From: Sue Howell
Sent: 09 December 2014 15:44
To: Planning.Responses
Cc: Simon Davis
Subject: RE: Planning Consultation on: Y/93/14/OUT

Comments from Greenspace

APPLICATION Y/93/14/OUT

Site Address: Land North of Yapton C of E Primary School
North End Road Yapton BN18 0DU

DRAWING NO YAP/DR/1

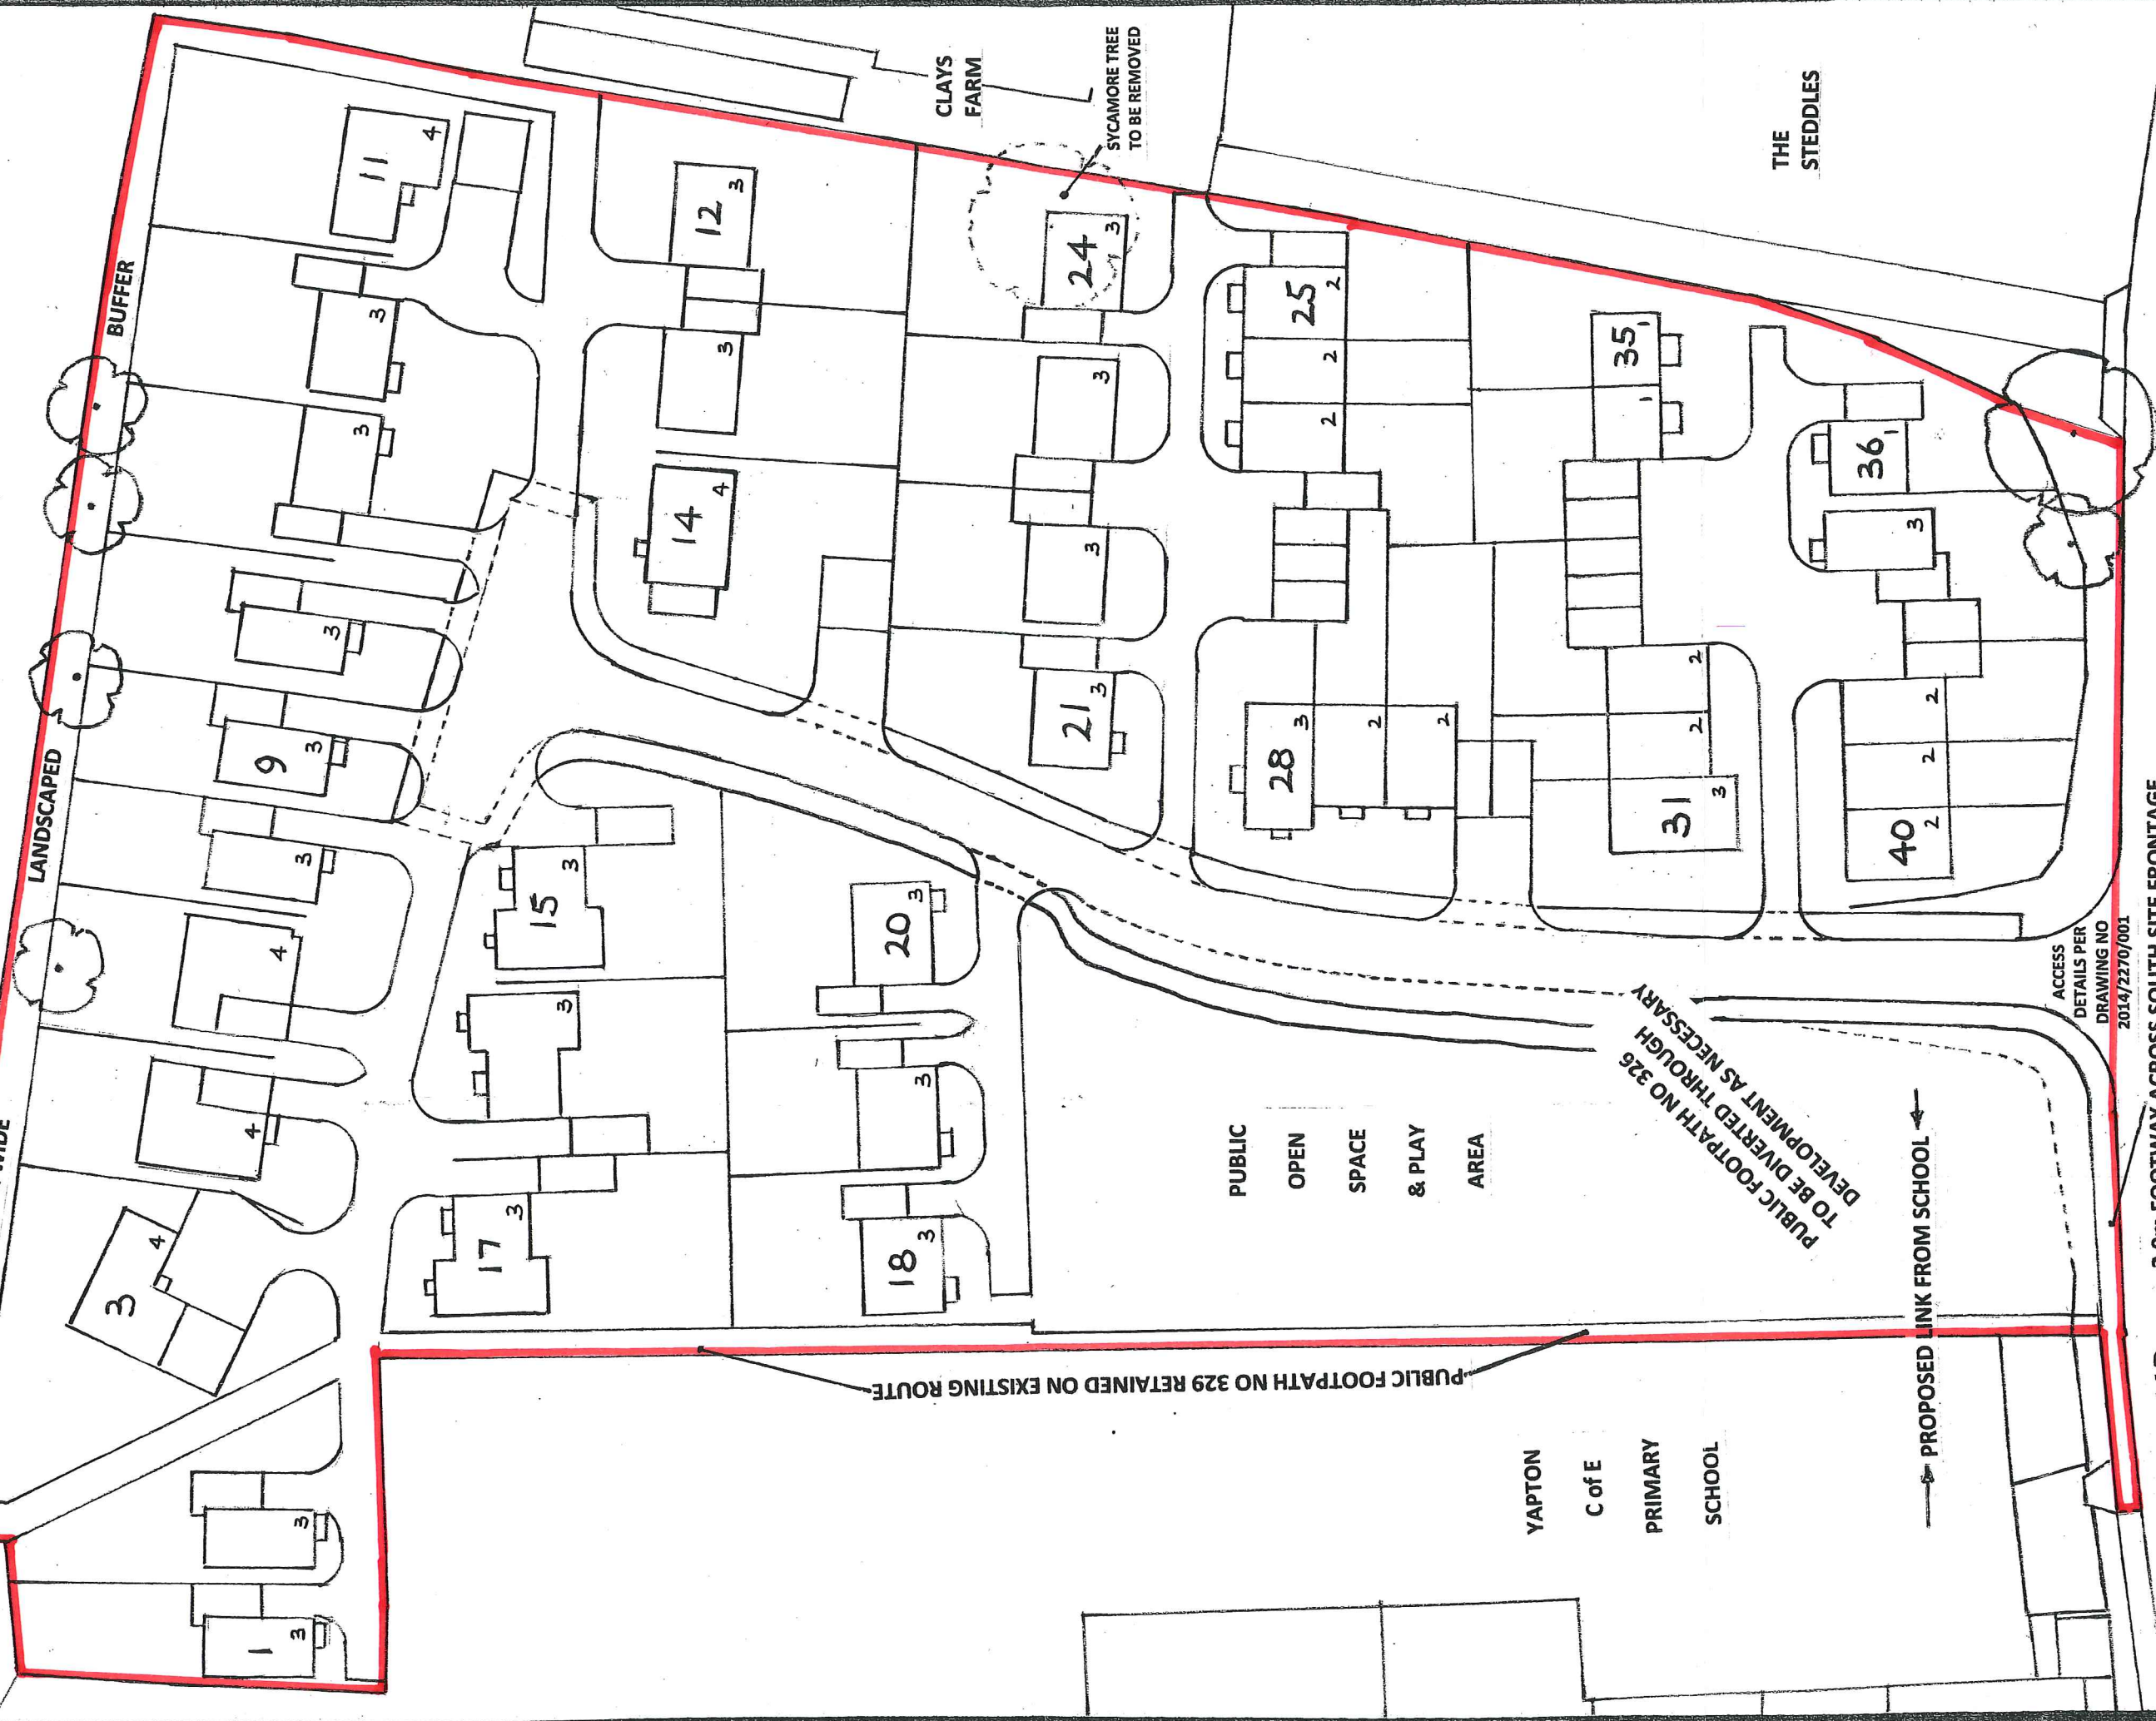
Forming part of the application and prior to any consent being given a full landscape scheme should be submitted for approval, detailing species choice, position, densities and size at time of planting. This should be plotted in plan and list form and in relation to the trees and vegetation to be retained in the locale, so that a clear picture of the proposals can be seen. These details are required to assure the adjacent land setting is maintained, the setting is uncompromised and the proposals are appropriate to its setting. Buffer zone and hedge enhancements are mentioned however these also need to be included in plan form detailing the extent of what the enhancements are. The indicative layout would appear to limit the available space for buffer zone and increased infill to hedgerow to the remaining boundaries, required to minimise the impact of the development on users of adjacent sites and routes.

Any trees or vegetation that fall within the proposed or periphery of the development, may provide significant aesthetic impact to the location. Any trees in particular along the boundaries, which adjoin neighbouring land could provide potential valuable screening and should be retained particularly those adjoining the settlement boundary. Any considered tree removal from this site should be agreed with Arun District Councils Tree Officer. Root protection Areas (RPA) should extend into the development site and to those in neighbouring land. Before construction, a tree protection scheme must be in place for any (If any) retained trees including trees whose root protection areas fall within the construction zone from neighbouring land. This should be in accordance with BS 5837:2012 'Trees in relation to construction' Any removed trees should be mitigated for allowing for inclusion of native species for biodiversity purposes and fitting to the semi-rural setting.

I would recommend that all of the above points are addressed as part of a complete and valid application and agreed before any decision can be considered.
